Erection of 3 No. dwellings, 1 No. detached garage, parking & alterations to existing access & driveway (resubmission following BR/200/16/PL).

Land to rear of 41 - 47 Pevensey Road Bognor Regis

Thank you for your internet representation made on 6th June 2018 which has been recorded as '**an objection**' with the comments as follows:

DRAWING TITLE	
Block & Location Plans and Site Section	
DATE	SCALE
Feb 18	1:200 @ A1
JOB NO.	DRAWING NO.
1615	2.13
	CHECKED BY
	REVISION
	DRAWN BY
	GIM

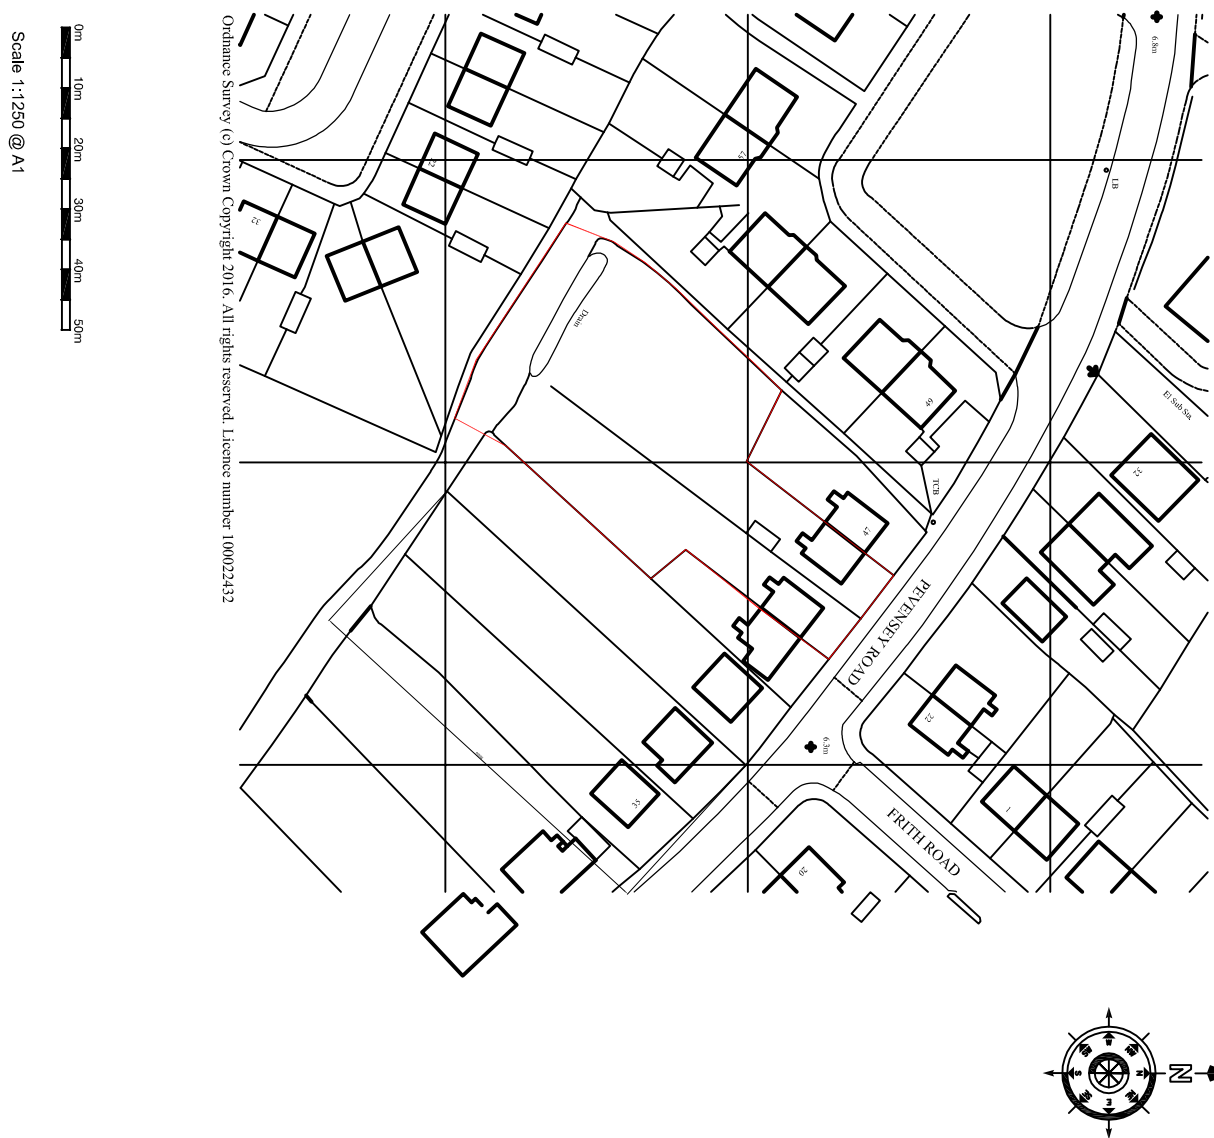
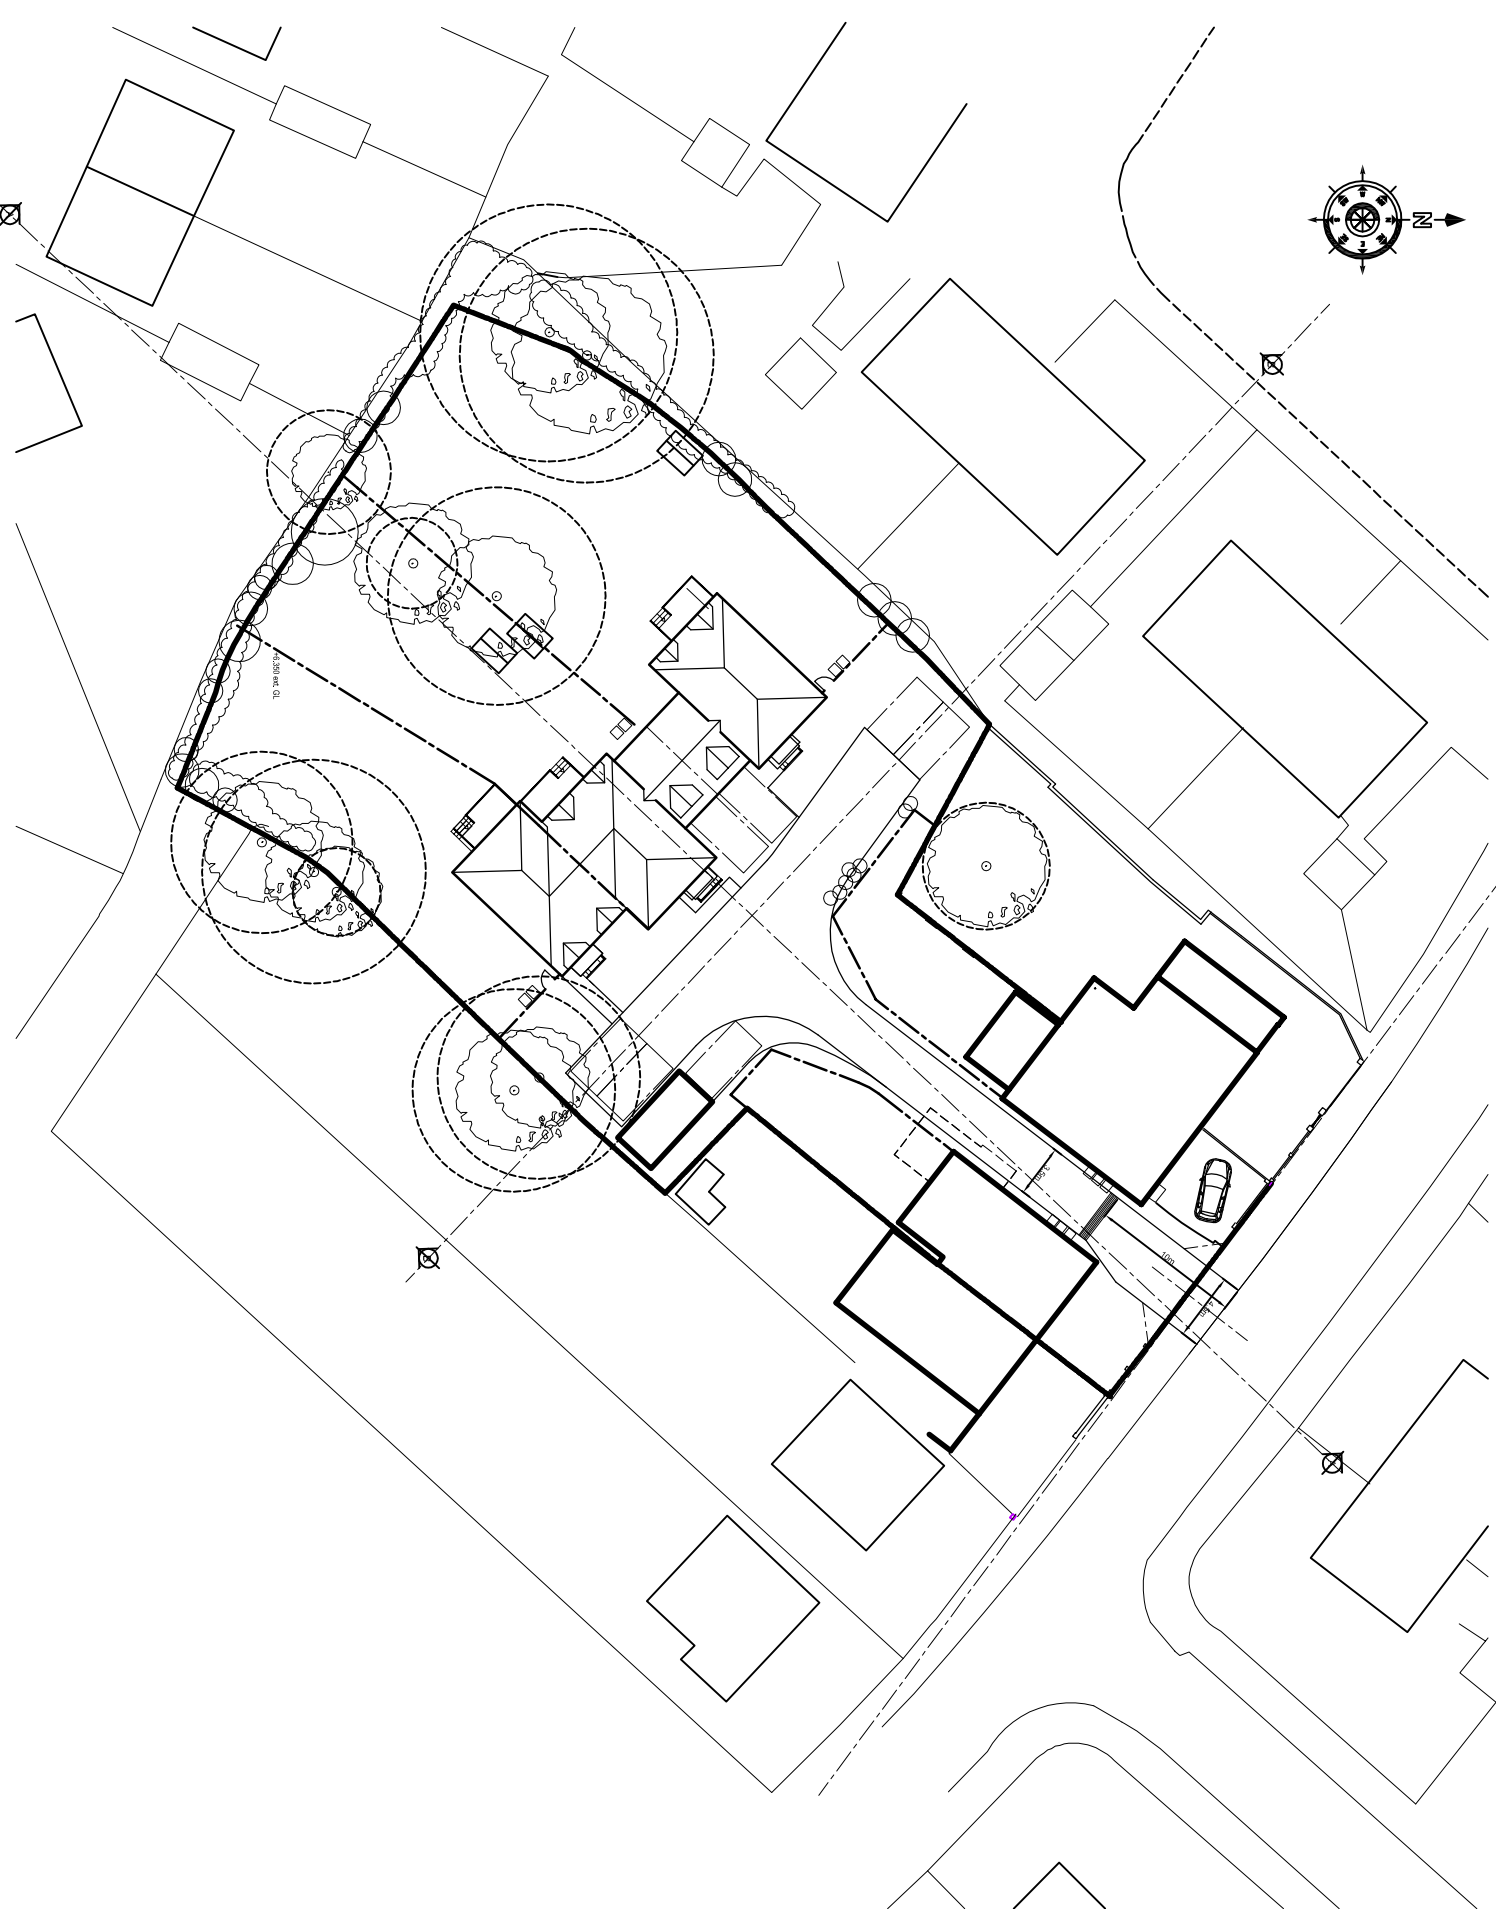
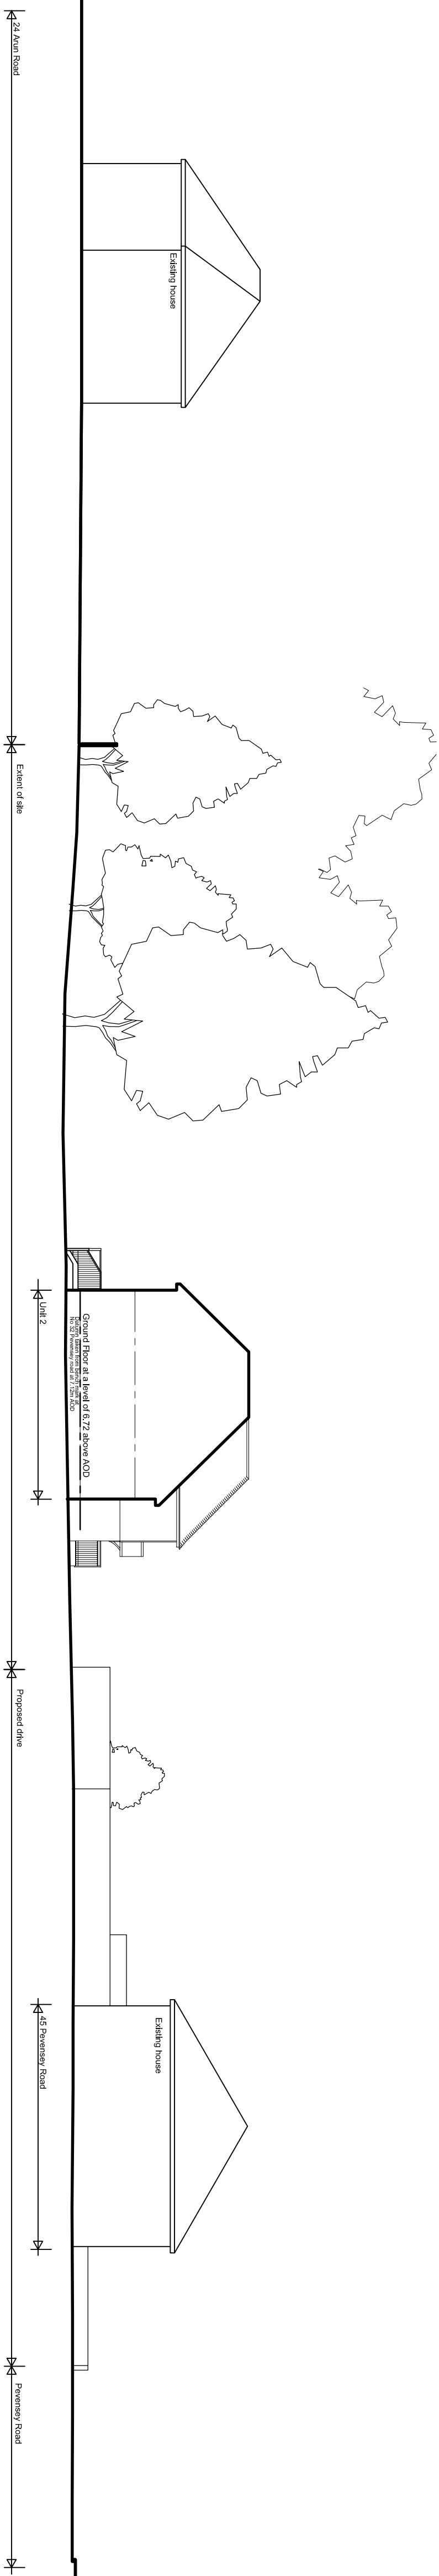
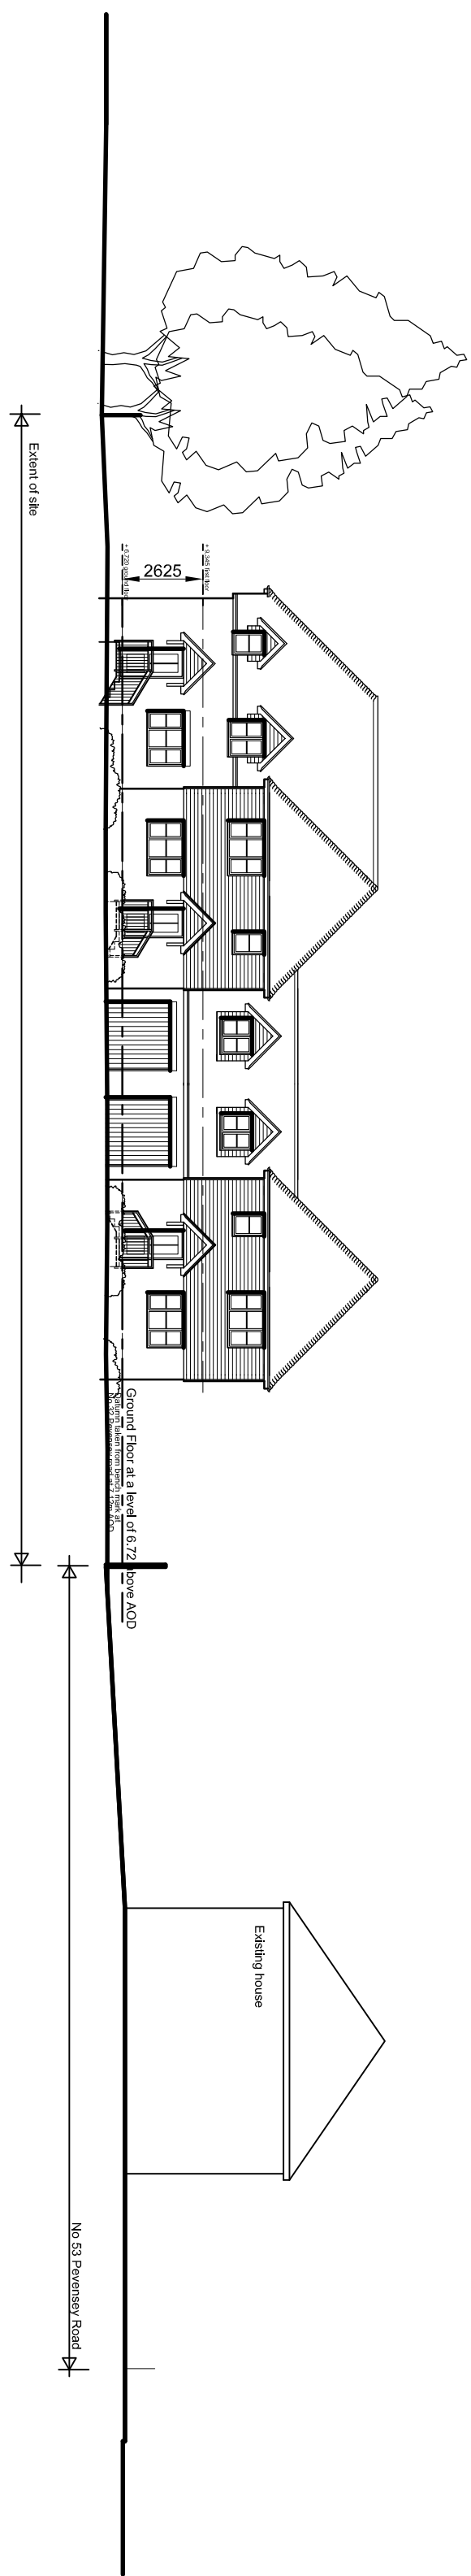
The car parking spaces are still on top of 2 protected trees roots the new proposed houses would still be far to close to the large trees, so trees would cause far to much shade and be a nuisance to new residents in blocking a daylight to the gardens and windows.

The 2 gardens are at different levels to each other one higher than the other, so how would it be possible to build a terraced row without altering land levels? As objections were raised from Arun council professionals last time and one of the points were the land levels weren't supposed to be altered at all?
